Department of Primary Industries

Our ref: OUT11/20811

**Re: Environmental Assessment for a proposed 50 Berth Marina at Lot 519
DP729020 – 19 Brisbane Water Drive, Koolewong (10_0209)**

Figure 1: Location of signage.

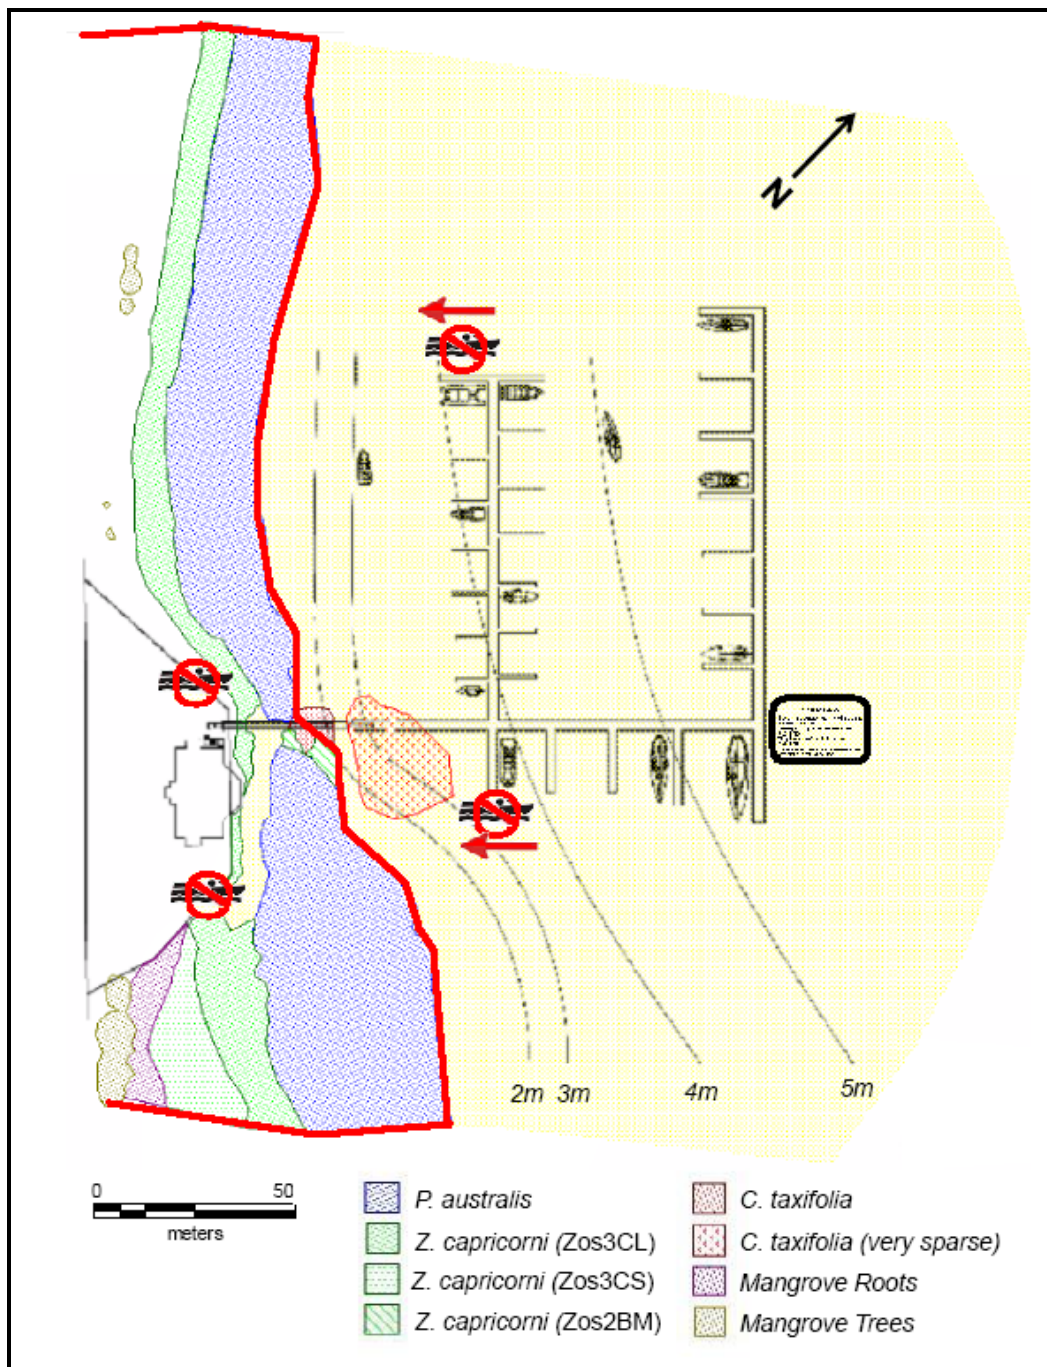
- Construction teams should be made aware of the presence and distribution of this environmentally sensitive area as part of the construction management plan documentation (CEMP);
- The importance of seagrass habitat, and details on how and why to avoid damaging seagrass should be included;
- Construction teams should be made aware of the importance of avoiding navigating over seagrass, particularly in shallow areas. If movements over seagrass are necessary during construction then these should be done at high tide, while travelling slowly and ensuring that adequate clearance is maintained between seagrass and propellers.

- To ensure all vessels avoid seagrass habitat it is advisable to deploy marker buoys outside of seagrass beds to give better visual indication of their outer extent;
- All vessels should be prohibited from deploying anchors within seagrass due to the likelihood of causing damage.
